23rd June 2026
Our Ref: D2380
Planning Ref: BN/64/26/PL

RE: HILL VIEW, EASTERGATE LANE, EASTERGATE PO20 3SJ

We write in response to the Arun District Council drainage consultee comments (18th June) in relation to the above planning application. BP Civils is responding on the applicant's behalf, as their appointed civil engineering consultant, assisting in flood risk and drainage matters in respect of this application.

PL400

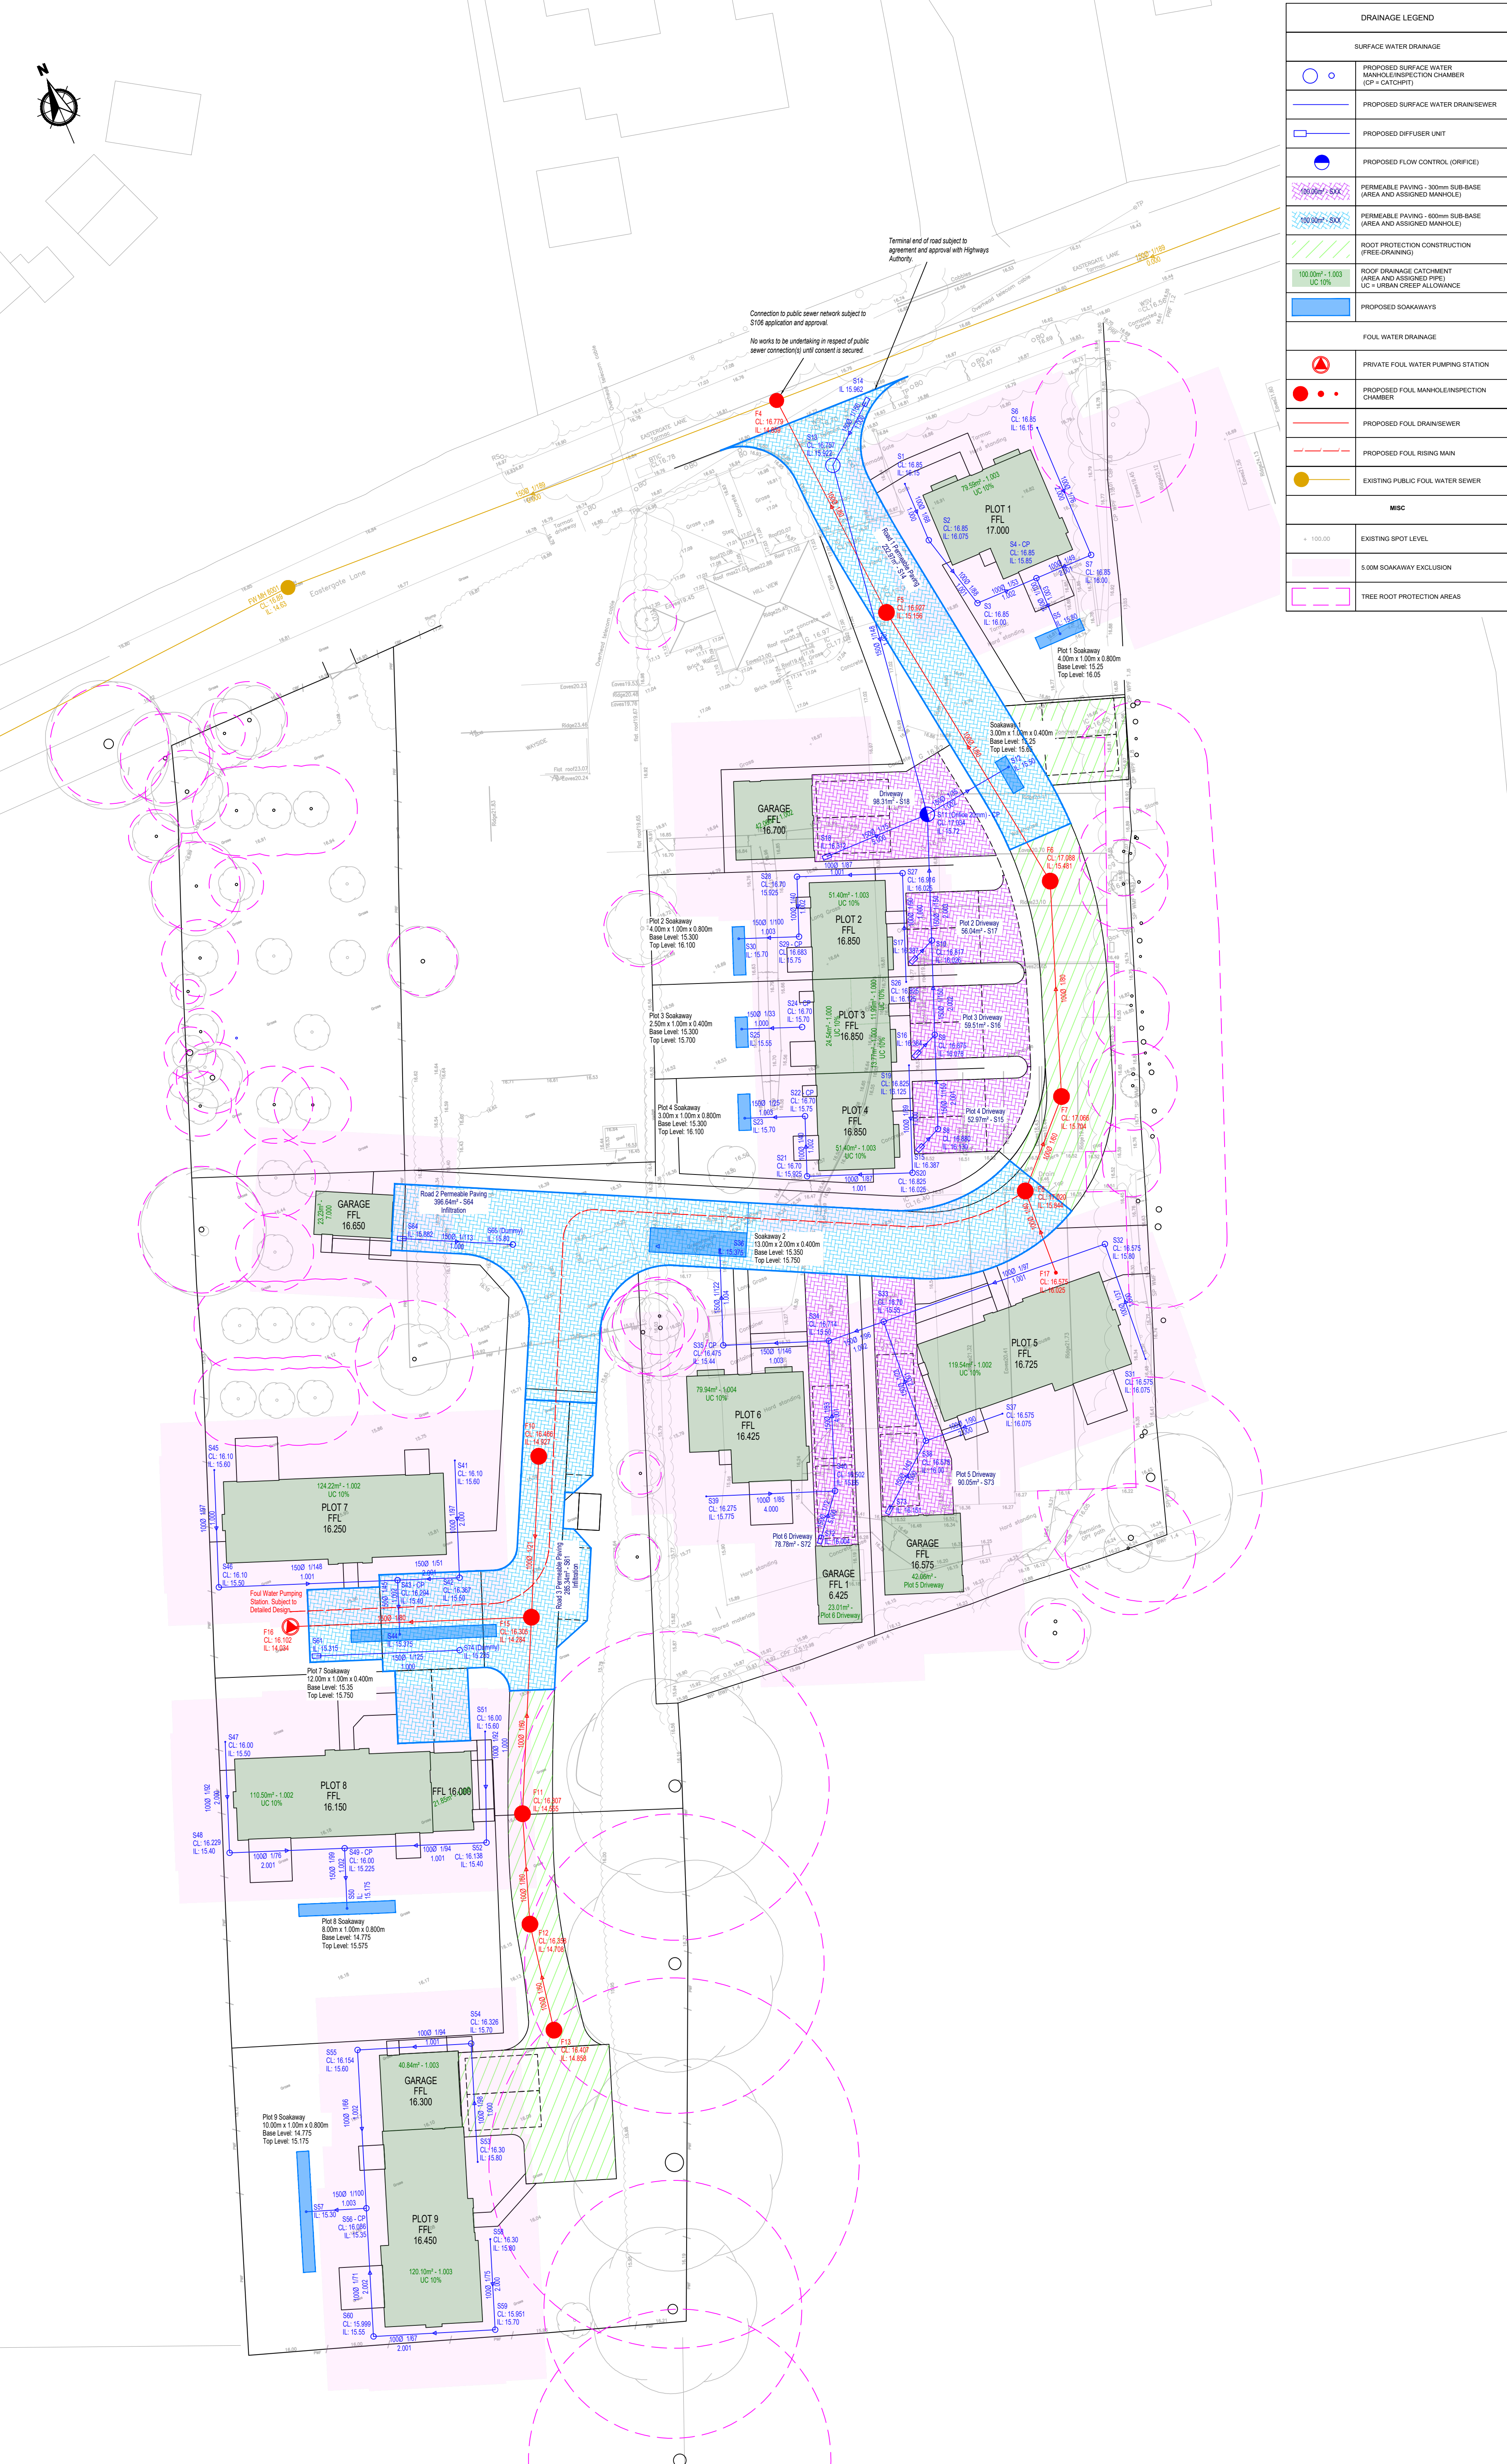
In respect of the comment raised concerning Plot 2's drained area, we believe that this comment infact relates to Plot 3. Only the rear of Plot 3's roof will drain to the soakaway within the rear garden of Plot 3. As demonstrated on drawing PL400 Rev. P2 (Conceptual Drainage Strategy) which was contained within the submitted drainage strategy report, this area totals 24.54m², excluding urban creep (0.003Ha as shown as the 'Catchment Area (ha)' within the calculations prepared). The additional areas – 13.77m² and 11.99m² – drain to the soakaways within Plot 2 and Plot 4's rear gardens. This is evident from the area totals as per the submitted calculations.

Additional comments were raised in respect of Standards 5 (Amenity) and 6 (Biodiversity), albeit no objection was raised concerning either standard. In relation to these two points, the proposed SuDS Pods/Planters have been included on the drainage drawing. Please refer to revision P3 of drawing PL400 (**Appendix C**).
